From: Sue Howell
Sent: 11 December 2017 14:58
To: Michael Eastham
Subject: RE: LU/121/17/RES - Toddington Nursery site

Re LU/121/17/RES

Please could I have your comments on the attached, amended Landscaping plan for Phase 2 of the residential development at North Littlehampton Strategic Development Area.

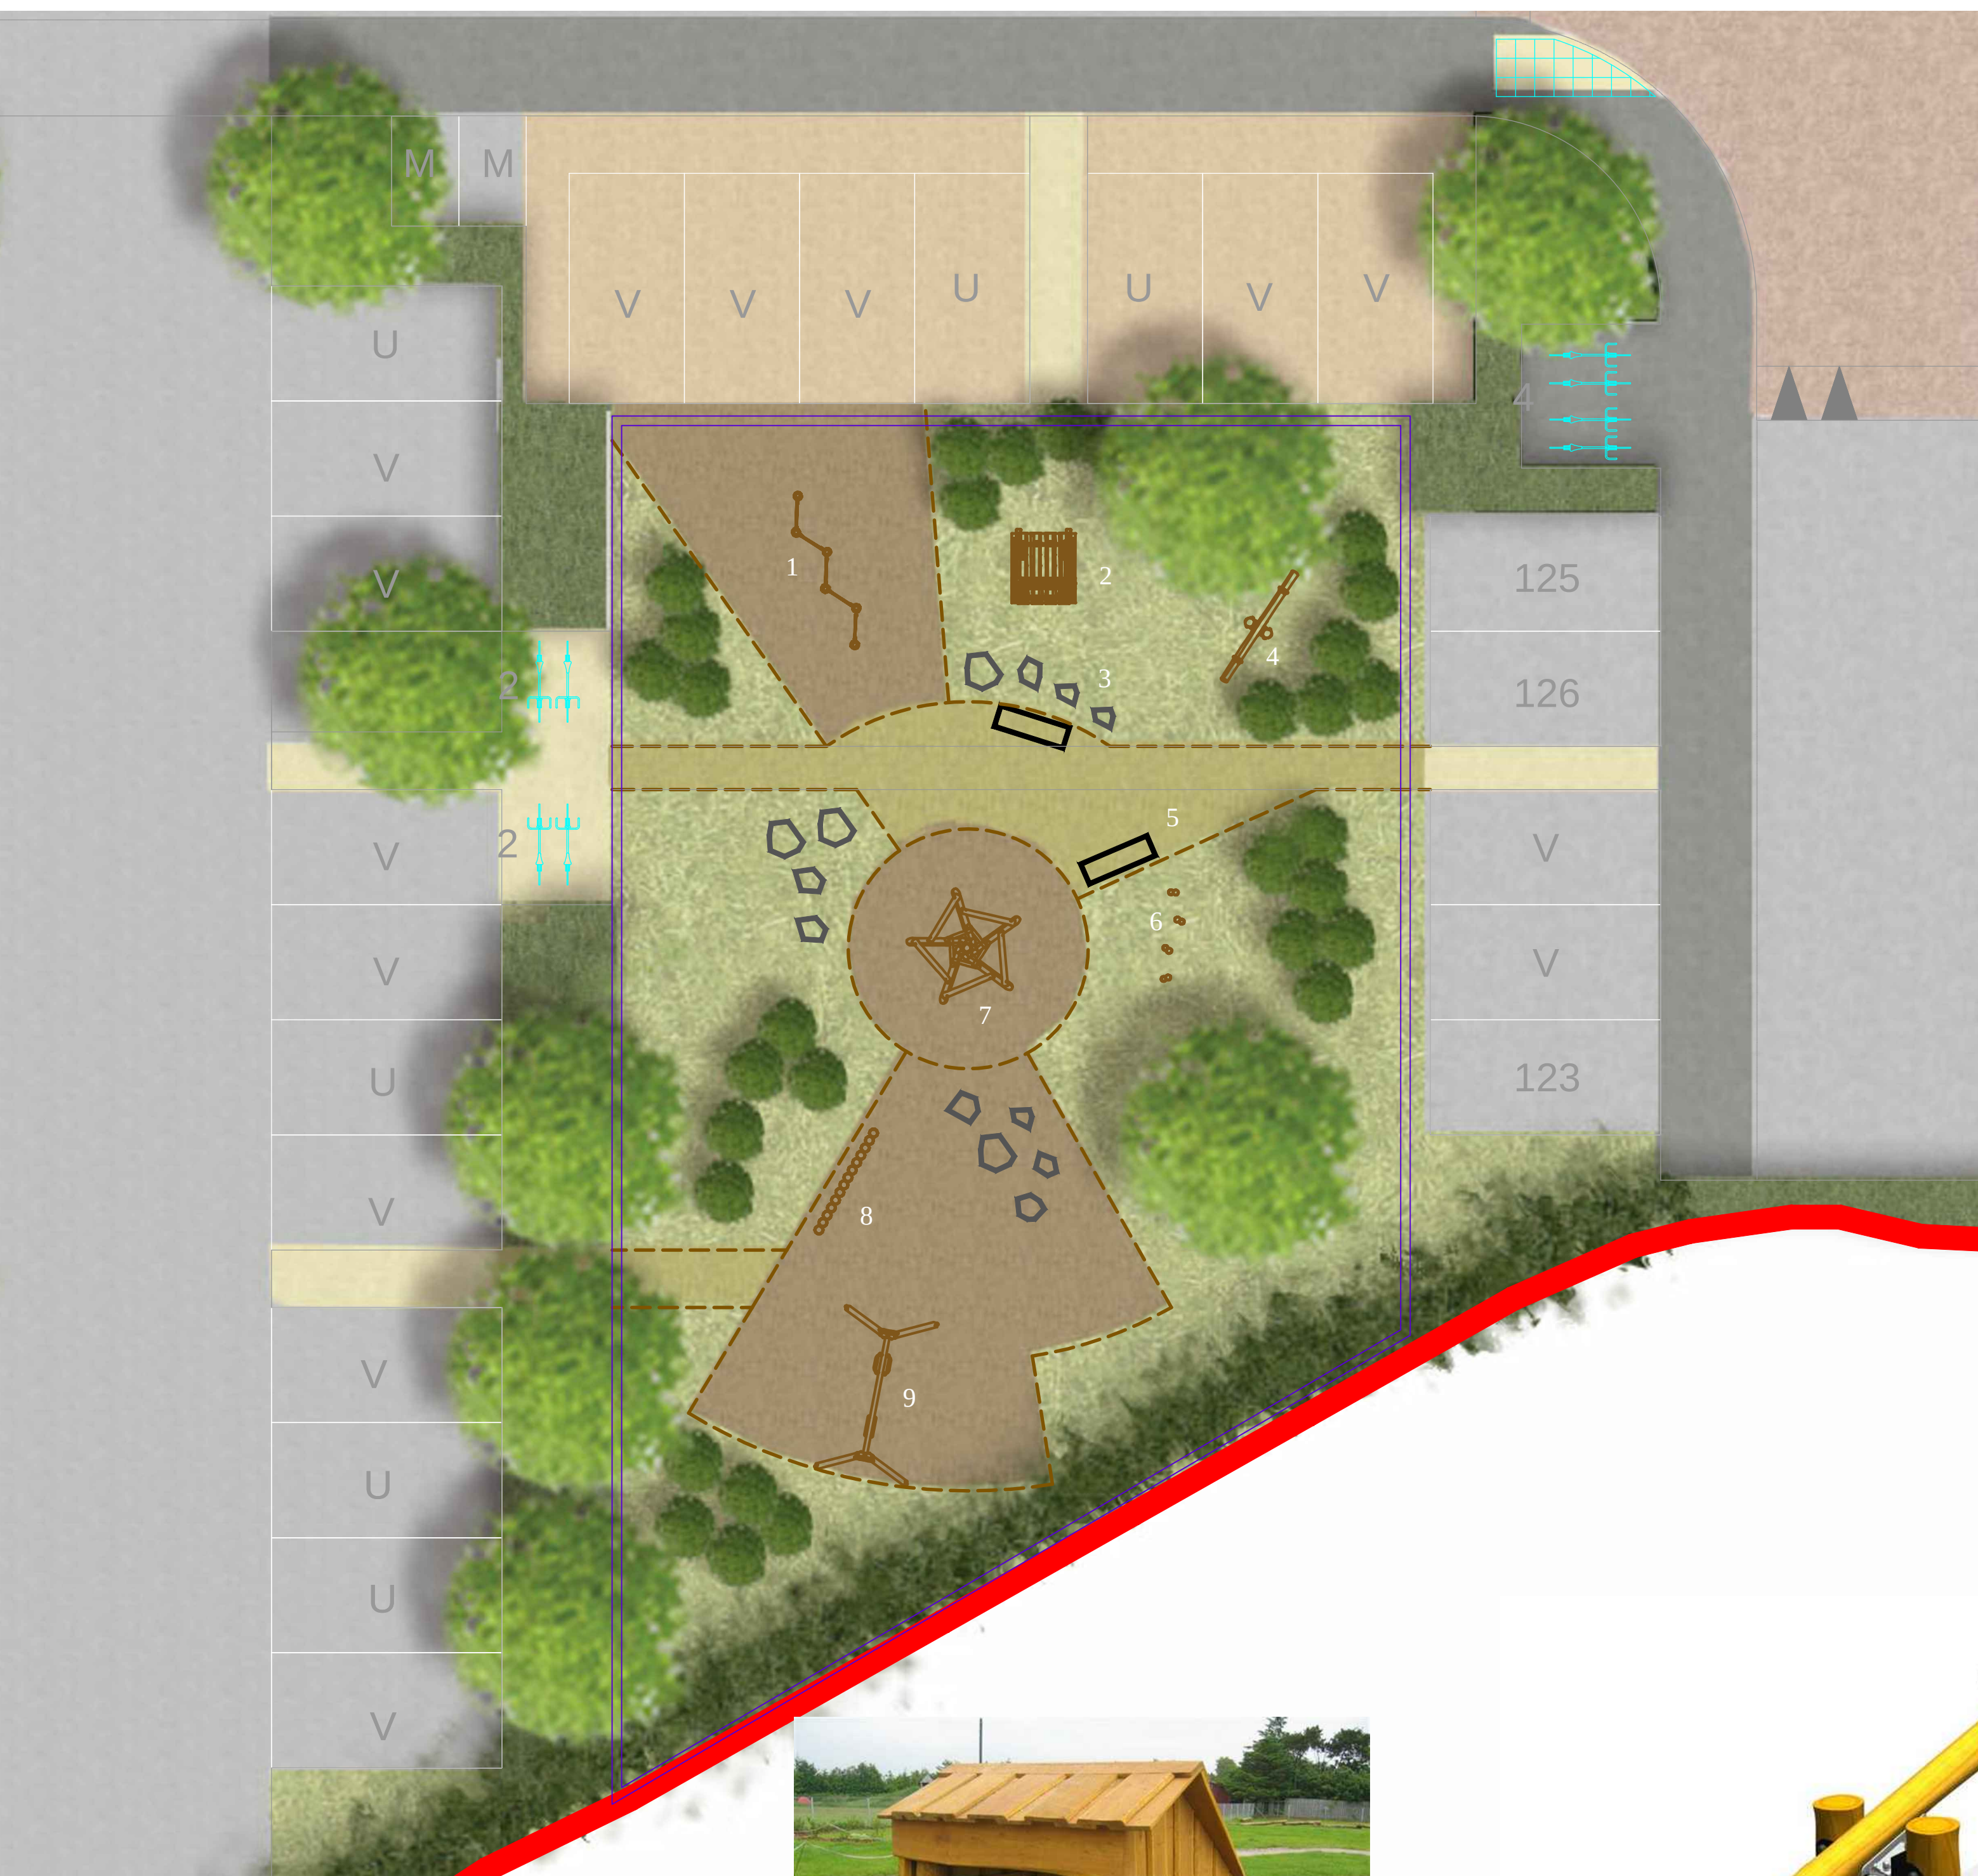
The LEAP Play proposals LA106 contained within drawing A0088461 LA100-107.dwg, does provide a good play experience with a variety of play experiences being provided for this younger age range. This has now also detailed fencing and gated play area detail.

General tree pit detail
Scale 1:10

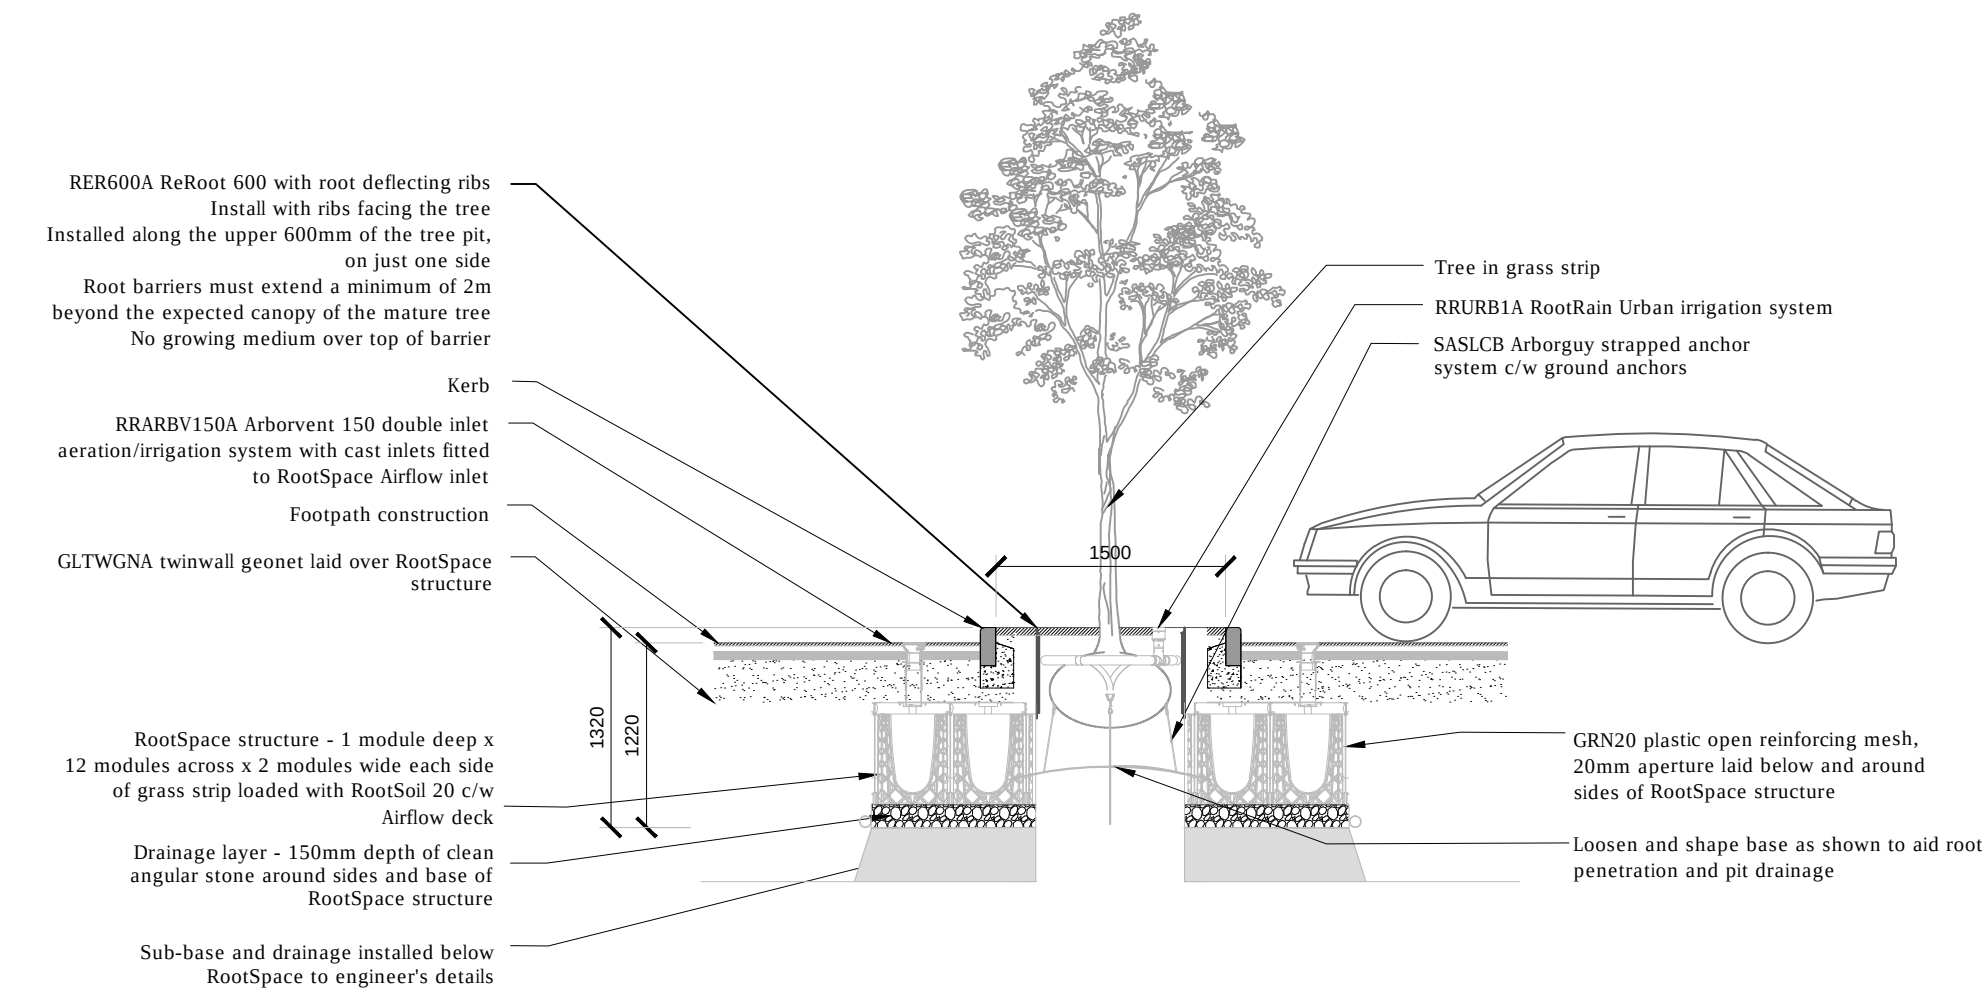
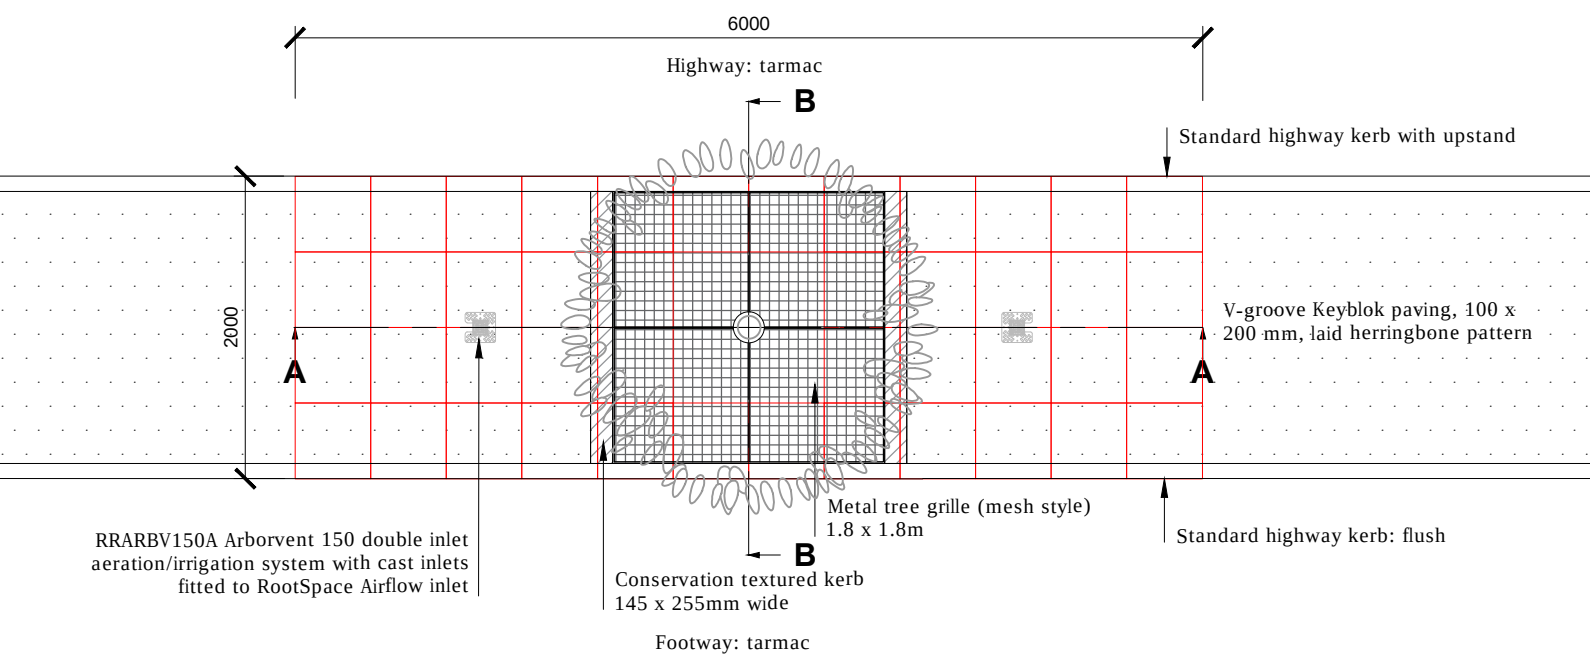
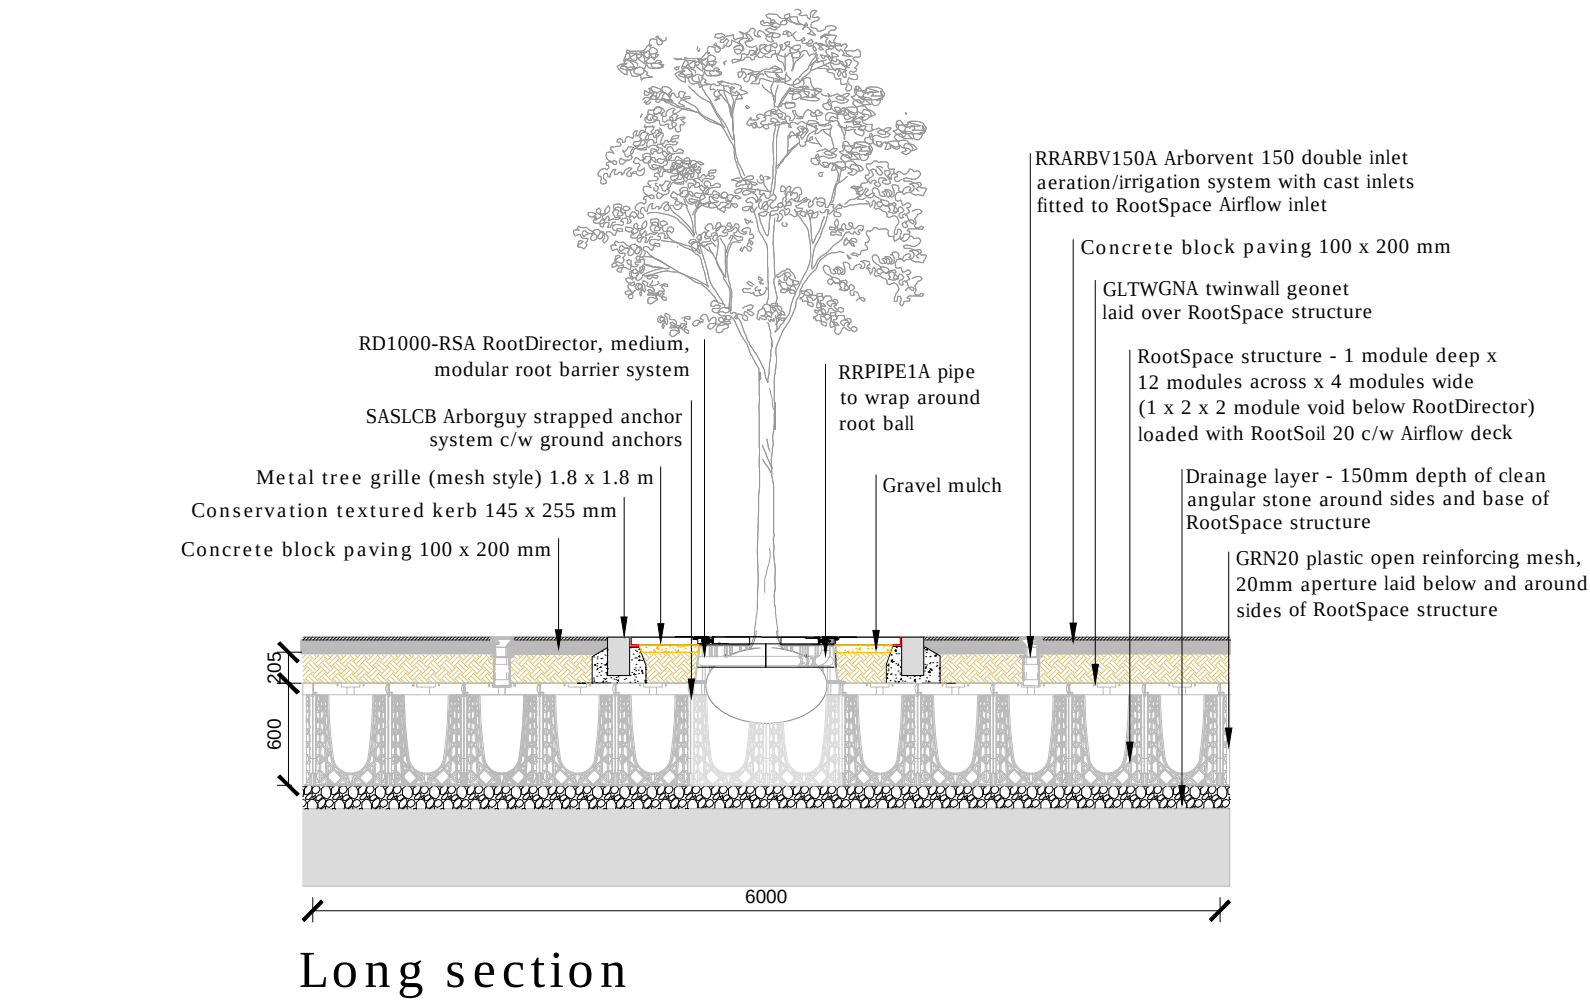
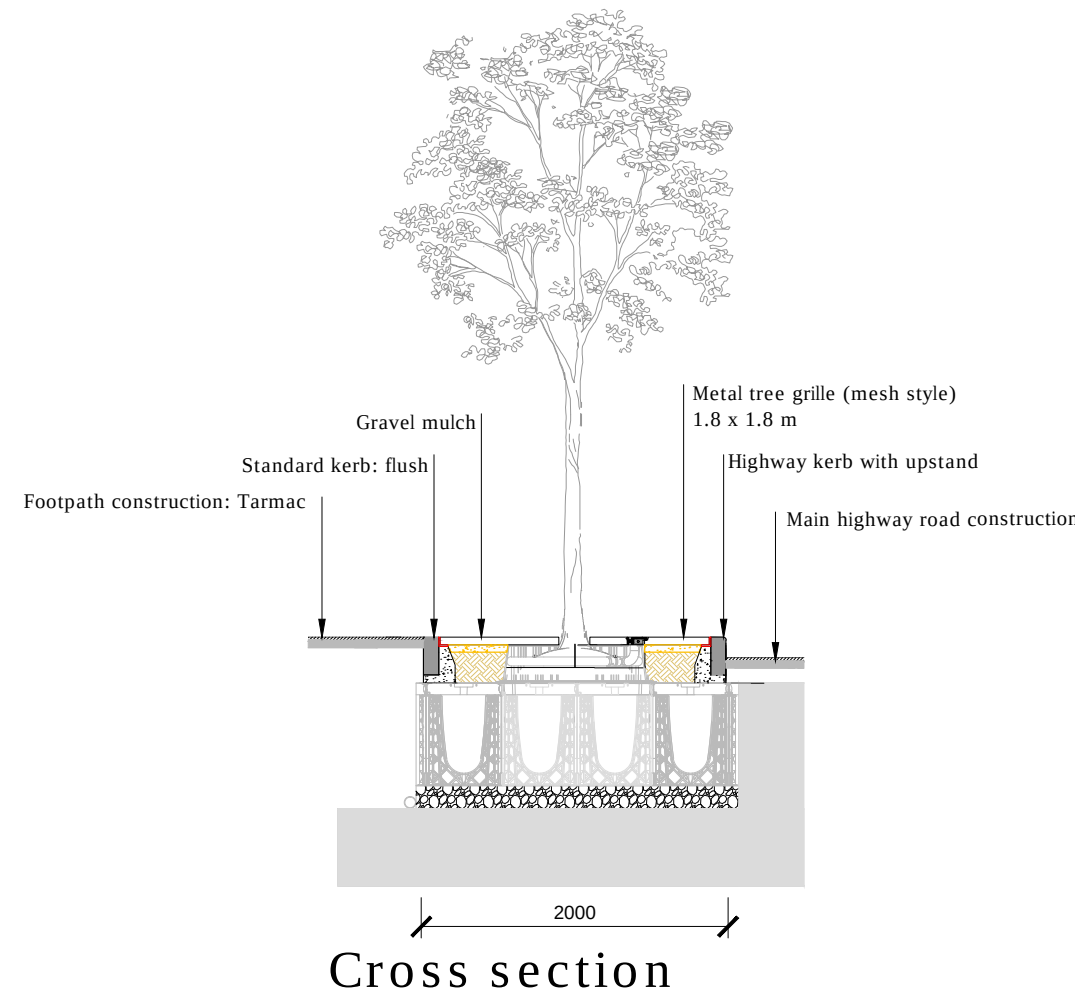
The submission of planting pit formation cross section and specification is good to see and this has shown detail regarding the inclusion of watering tubes and 'deadmen' underground guying systems. The detail for the trees to Main Avenue includes a root support system which includes growing medium specification, root directors/barriers, aeration system, irrigation and anchors. This attention to detail along with adequate follow up maintenance and watering to establishment should support long term thriving growth and establishment.
